Name	City of Gosford Design Advisory Panel – Design Reference Group (DRG) Workshop: 1 Dane Drive, Gosford
Location	Department of Planning Industry and Environment (DPIE) 320 Pitt Street Sydney, Level 26 Tea Tree Room
Date/Time	Tuesday 30 th July 2019, 1:00pm – 14:30pm
Chair	DRG member
Attendees	Robert Hodgkins (DPIE) Louise Starkey (DPIE) Paul Walter (DRG) Simon Kilbane (DRG) James Harrison Jay Griffin Mark Curzon Andrew Dickson (Leagues Club) Mike Dowling (Leagues Club)
Site	1 Dane Drive, Gosford, Central Coast Leagues Club

Meeting Notes

SOLAR DIAGRAMS

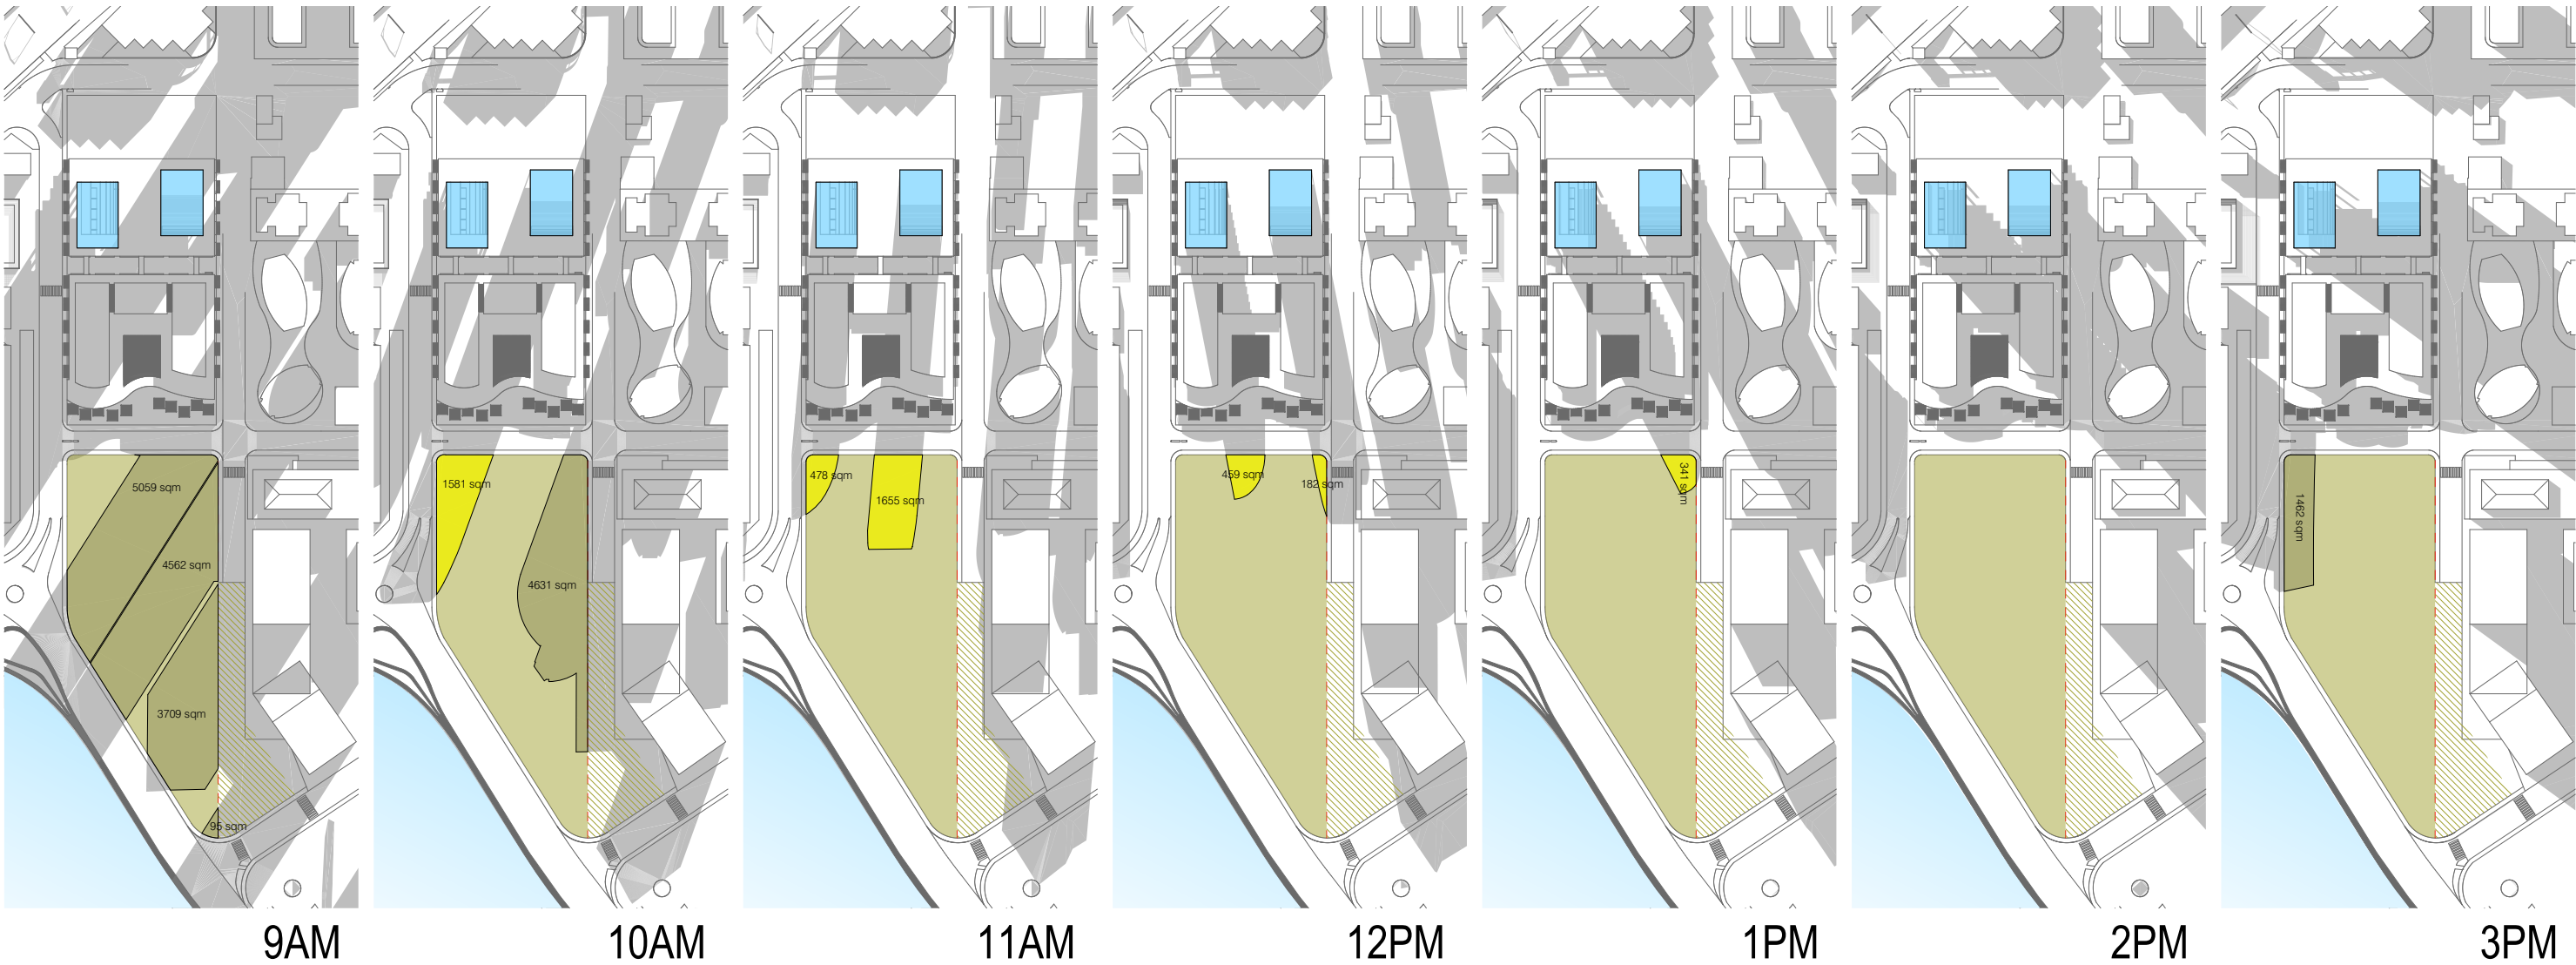
- The massing approach which presents a lower edge to the park and places the taller elements in the north is broadly supported. The shadow diagrams appear to demonstrate impacts on the park meet prescribed performance measures

PRIVATE OPEN SPACE

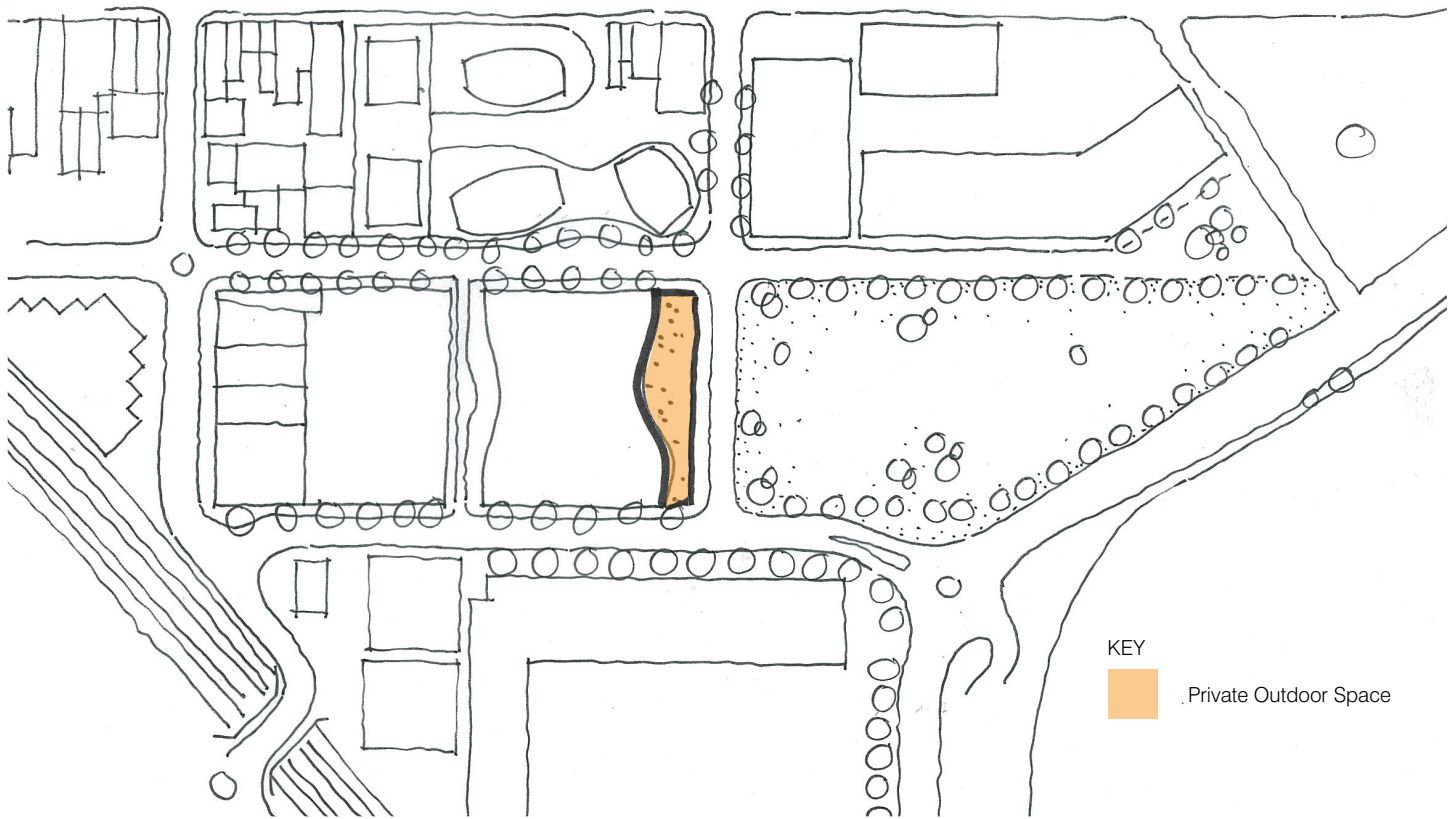
- In relation to the plaza forecourt:
 - It would be a large overshadowed space facing a large open space (Leagues Club Field)
 - The proponent intends to break up the southern façade so it presents as multiple tenancies

- The club will have an internal light well which will allow light in to the club and plaza/forecourt
 - It was recommended that the proponent explore opportunities for more light to access the plaza/forecourt area

THROUGH SITE LINK

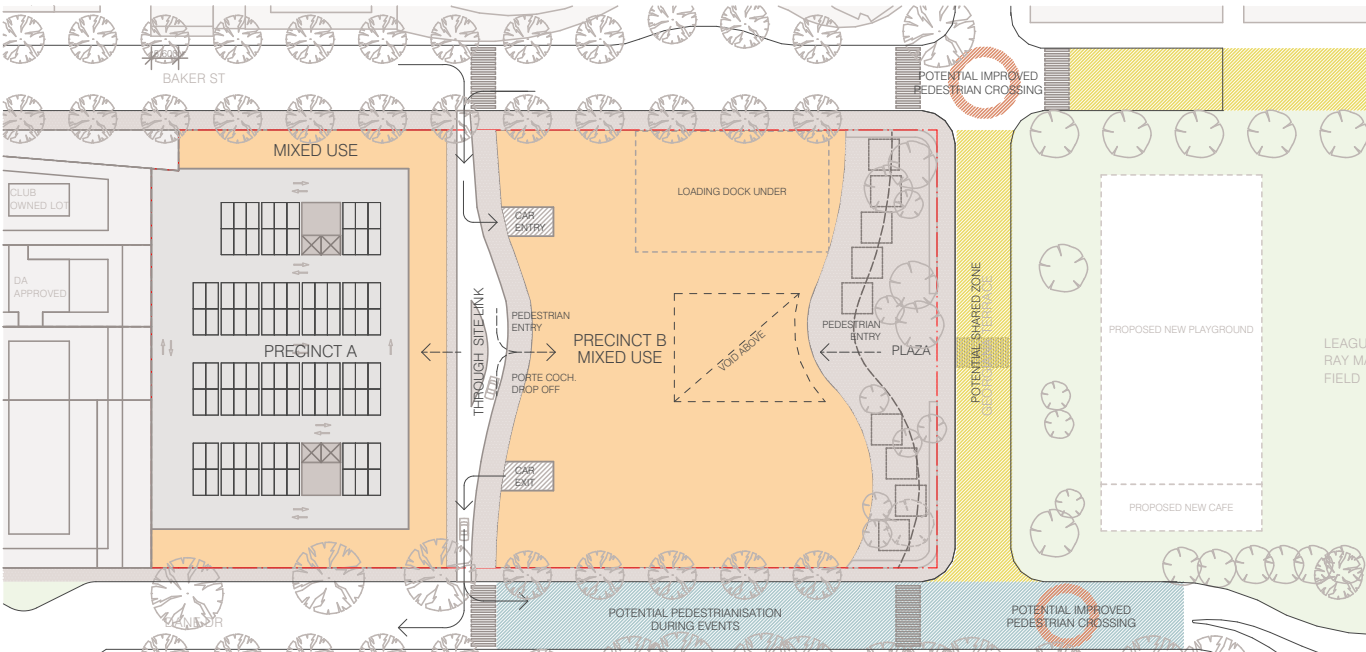
- The internal street / laneway is a positive move to break up the site, increase permeability and to provide additional access
- Opportunities to link in with the stadium, Leagues Club Field and other nearby development are positive. (Diagramming these relationships and the entry/exit points of these adjacent opportunities would be useful)

- The through-site link also needs Crime Prevention Through Environmental Design CPTED principles applied to its design
- It was noted that the hotel/conference centre concept is evolving and the club is still in discussions with potential operators – it could include 200 beds and conference facilities
